Appeal Decision

Appeal Ref: APP/R5510/W/21/3284627

16 High Street, Northwood HA6 1BN

Proposed Southern Elevation for 16 High Street Northwood
(1:100 @ A1 or 1:200 @ A3)

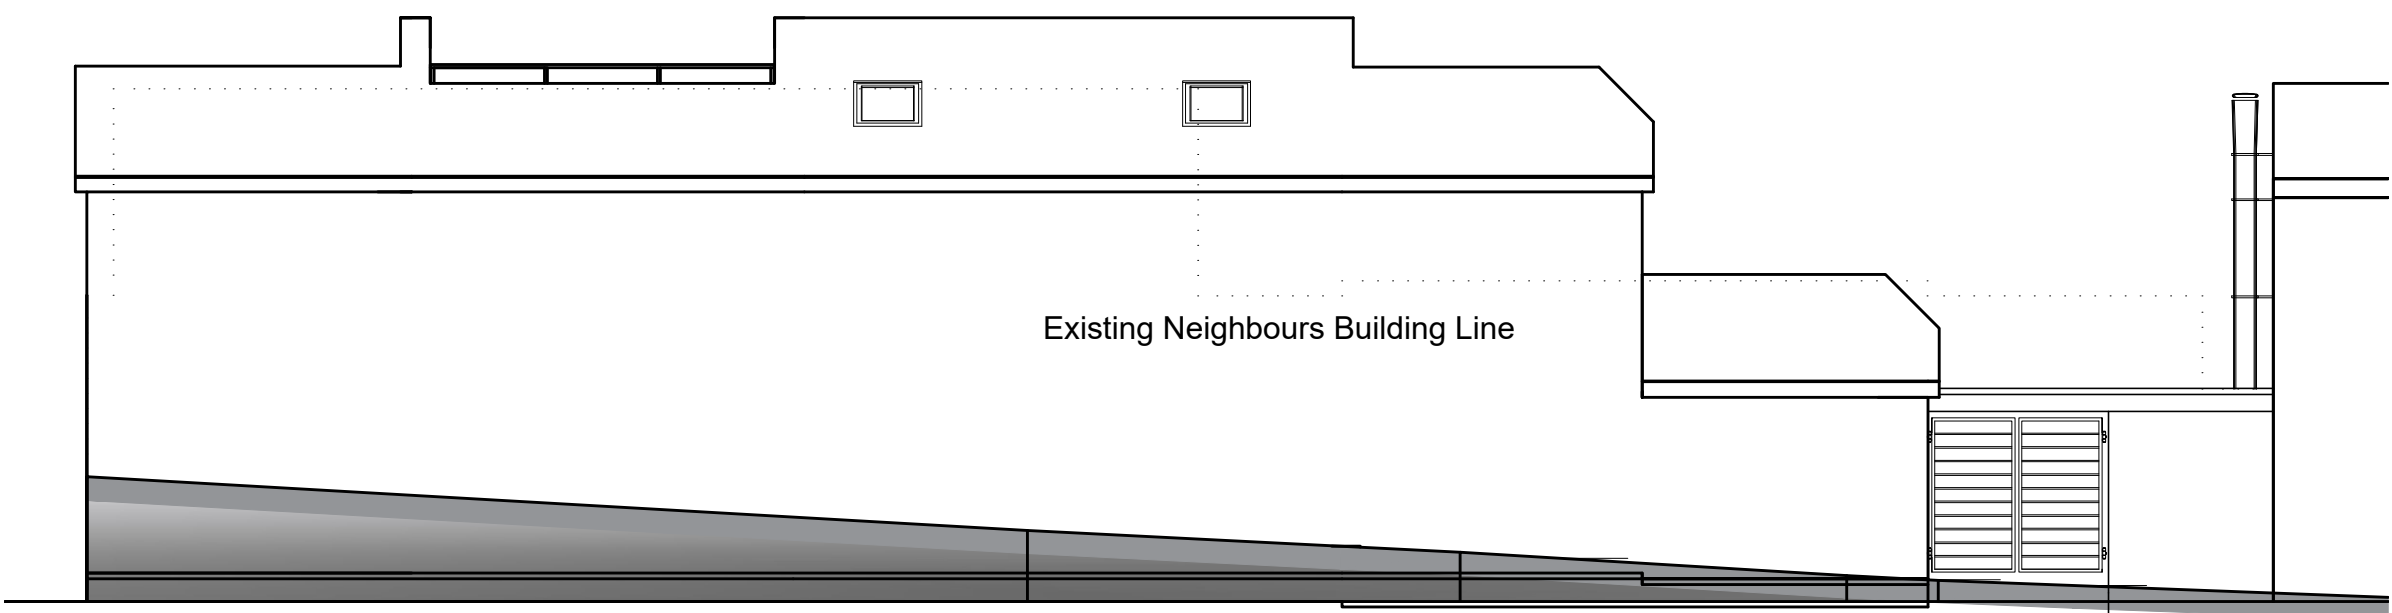
9. The proposed two-storey built form would be situated at sufficient distance away from existing residential properties to ensure that it does not appear overbearing to neighbouring residents, or cause a harmful loss of sunlight and daylight. However, the first floor bedroom windows sited to the southern elevation of the development, together with the open staircase providing access to the flat, would enable clear views onto the adjacent sites, and from a modest distance.
10. This would cause a loss of privacy to the occupiers of these neighbouring properties, which would have a detrimental effect on their living conditions. The appeal scheme would consequently conflict with Policy BE1 of the LPP1 and Policy DMHB 11 of the LLP2, which states that development proposals should

13. Due to the tightly constrained nature of the site, most of the openings would be situated to the southern elevation of the new dwelling. This would be at odds with the Mayor of London's Supplementary Planning Guidance (SPG) on Housing⁴, which seeks to minimise the development of single aspect dwellings. Dual aspect dwellings, which are fitted with openable windows on two external walls, either on opposite sides of a dwelling or on adjacent sides, are considered preferable.

14. The eastern and western facing windows would provide additional light to the living area, but the outlook from these openings and the daylight/sunlight would be restricted due to their size and proximity to the adjacent walls. Future occupiers of the development would not therefore be provided with a suitable dual aspect. Due to the flat's layout and the size of the openings, and in the absence of windows on any of the remaining elevations, it is likely that future occupiers would have to rely excessively on artificial light, thus resulting in a poor standard of accommodation.
